OAKLANDS FARM SOLAR PROJECT – EN010122

Section 51 advice regarding draft application documents submitted by Oaklands Solar Farm Limited

Drawing Title
**Works Plan
Sheet Overview**

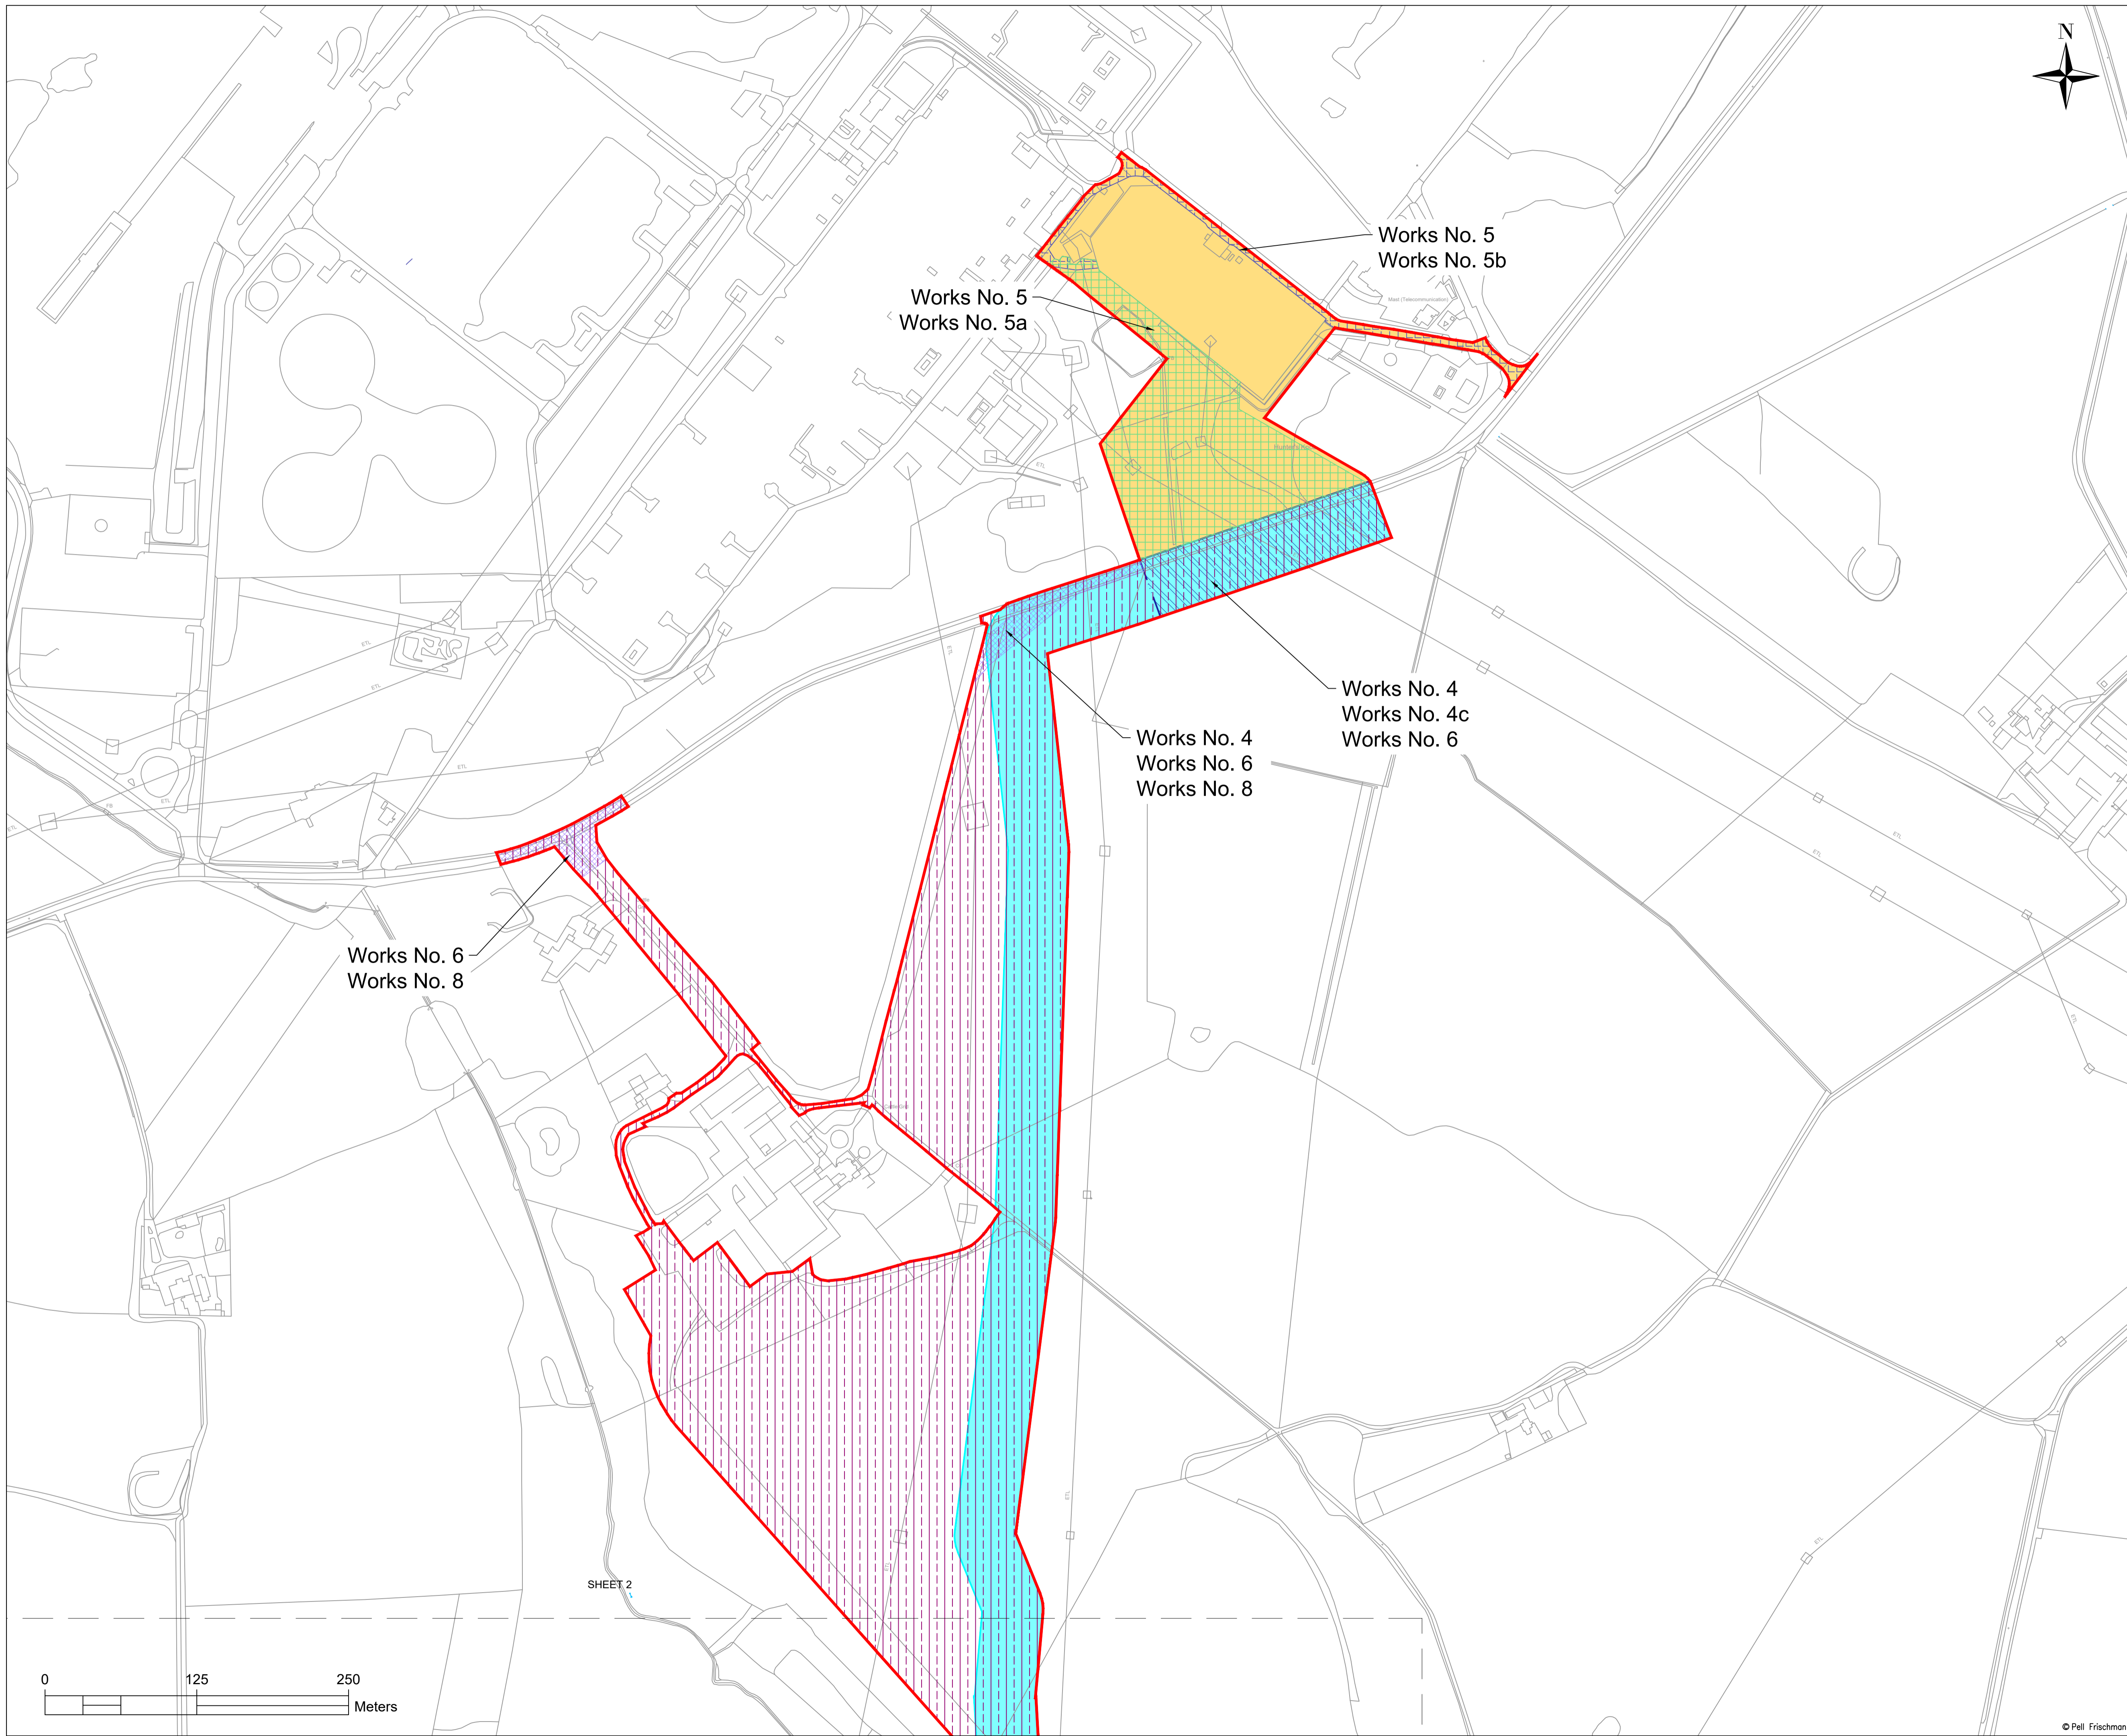
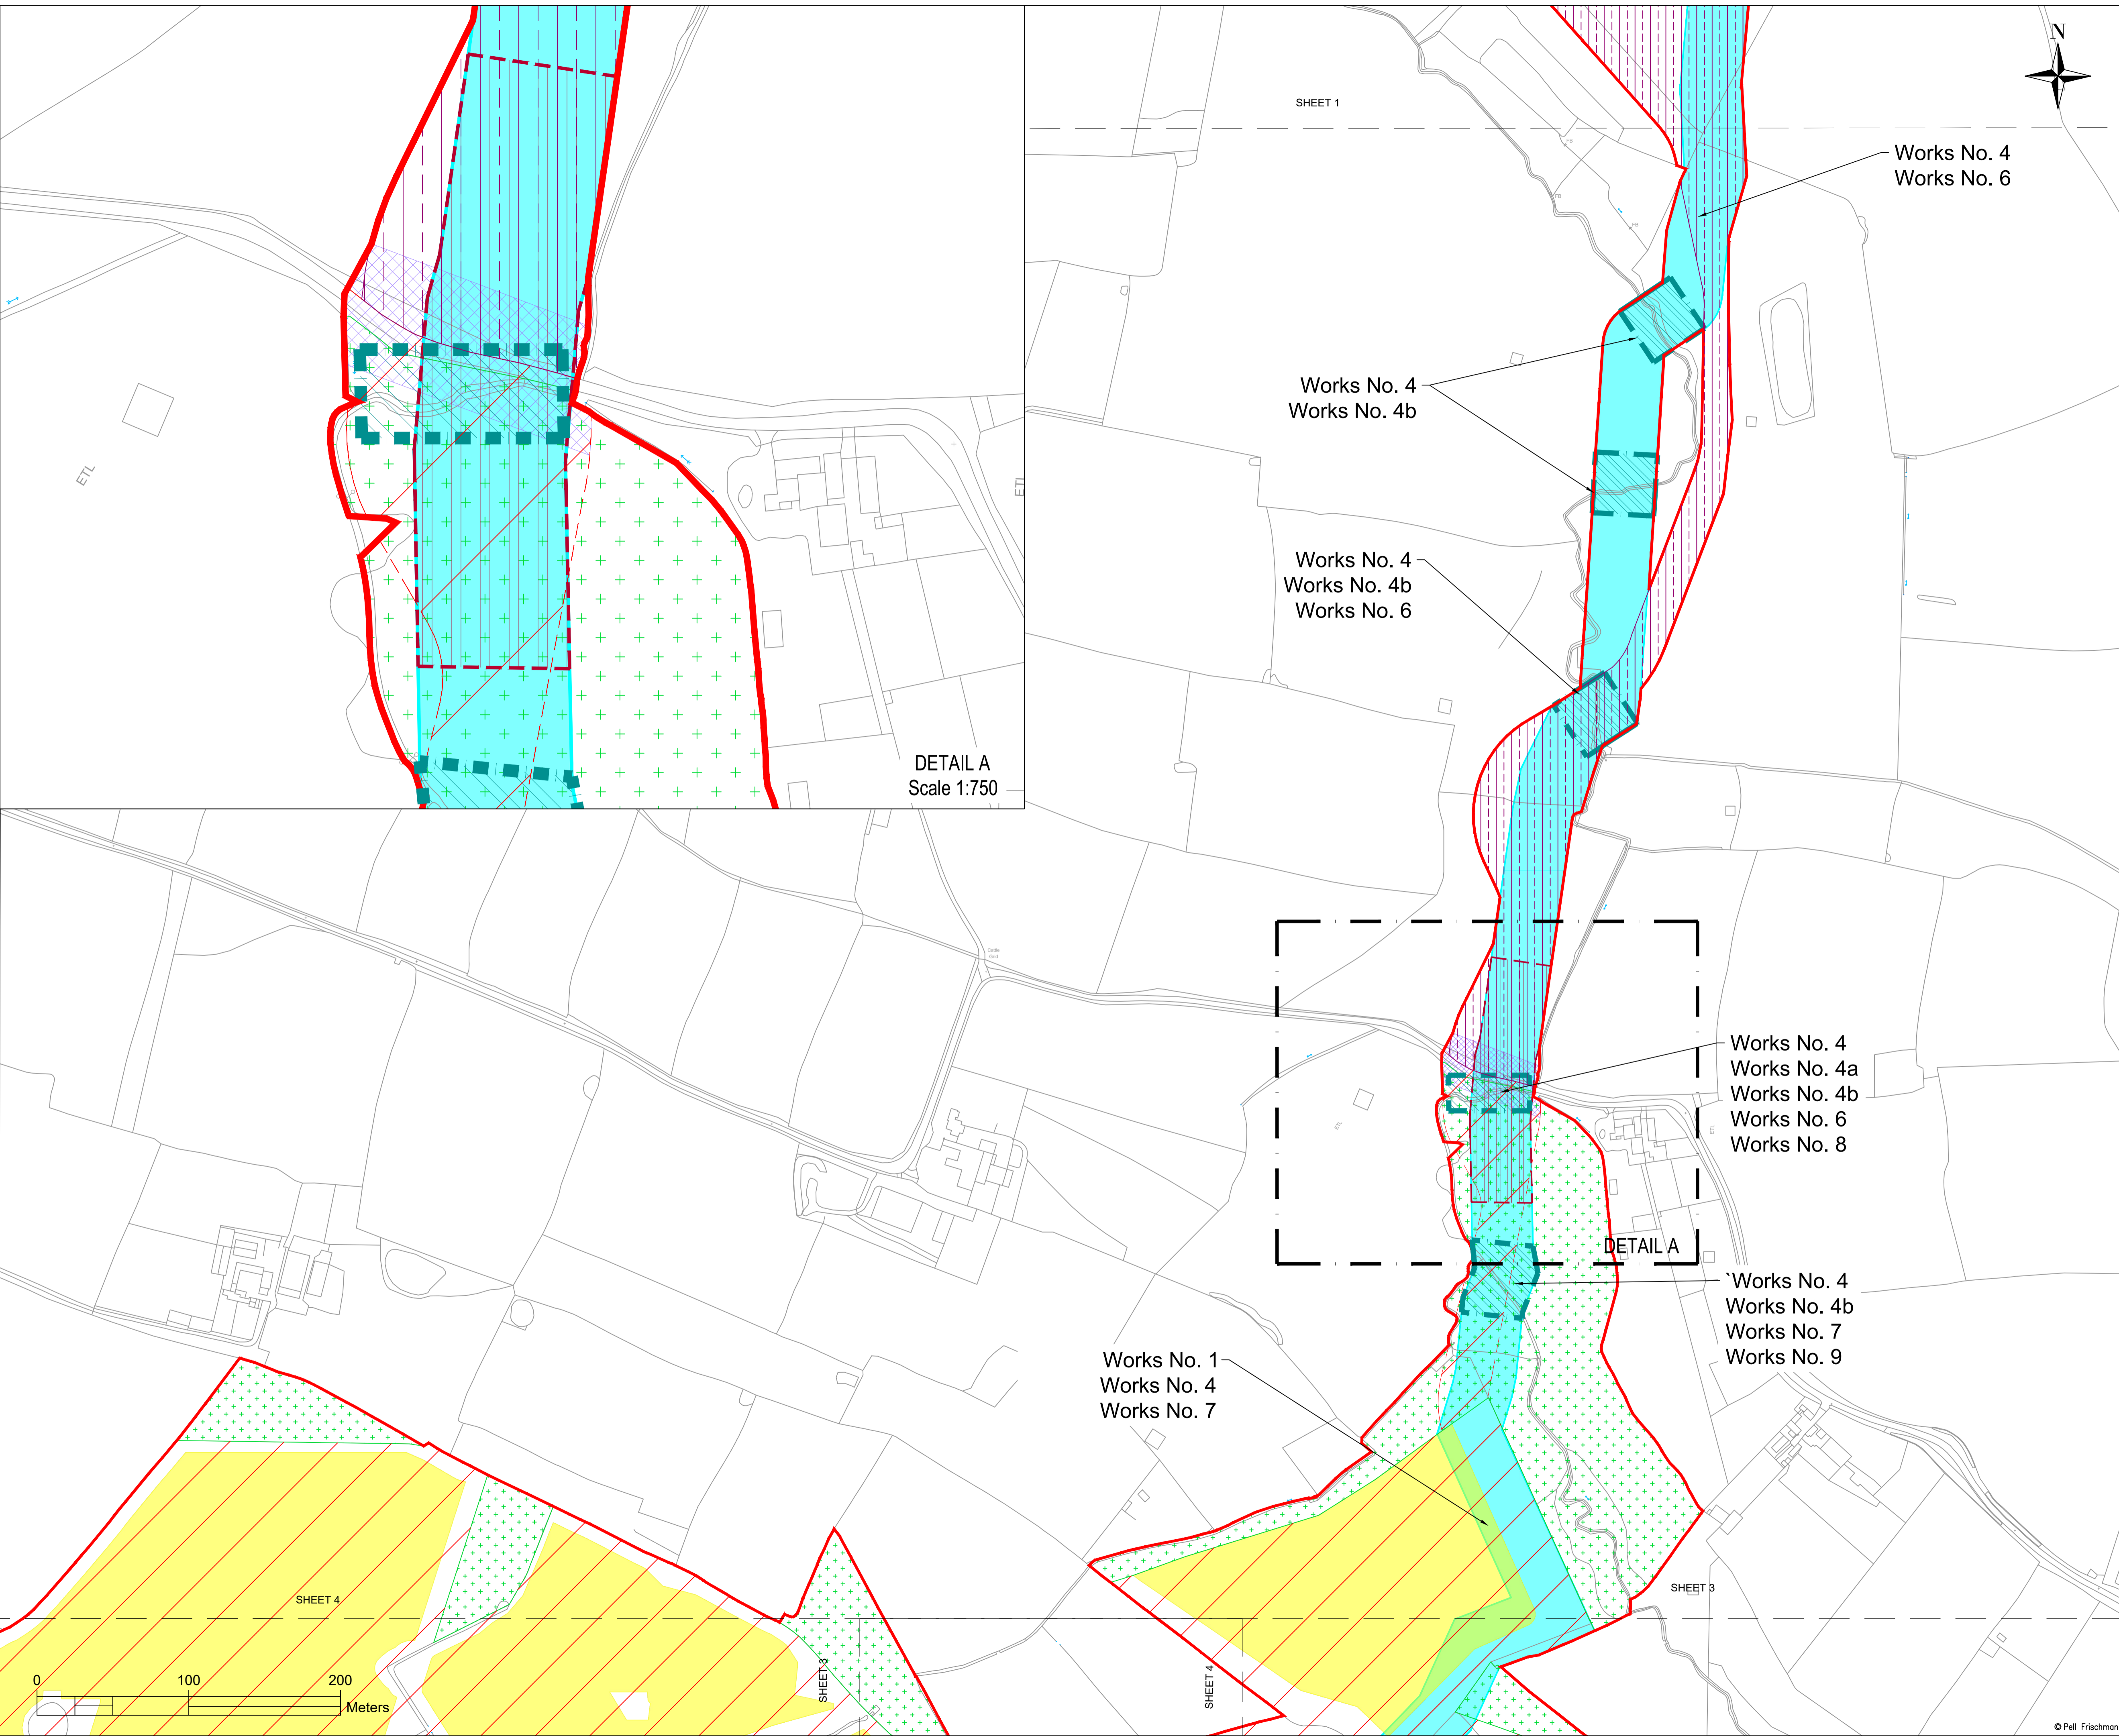
Work Plans		
Ref No.	Plan ref	Comment/Question
66.	General	The client referenced on each drawing is ITP Energised rather than Oaklands Solar Farm Limited and is therefore different from the Applicant notified to the Secretary of State at the time of the section 42 Statutory Consultation in April 2022. The Applicant should review this and determine whether this is an issue or provide clarification of the connection between the Applicant and other bodies referred to in documents submitted as part of this application.

Work Plans		
Ref No.	Plan ref	Comment/Question
67.	General	Ideally there would be clear cut lines on each sheet of plans provided to the Inspectorate for the ease of understanding the extent to be covered on each sheet and the extent of overlaps of plans. Whilst all plans may be based on the same model space with separate paper spaces being used for each separate sheet it is important to understand where there is an interface between sheets and to assist the Applicant and others in understanding the plans. The Applicant may wish to reflect on the approach taken to the interface between sheets for the benefit of the Applicant and other parties and amend the approach as considered most appropriate.

68.	Sheet 1 and Sheet 2	Linked to the previous point there is not a large overlap of Sheet 1 and Sheet 2 of the Work Plans, and it is unclear whether part of area forming part of the proposed project is not covered between these two plans. The Applicant may wish to check this and take a view on whether they wish to modify the area covered by each sheet.
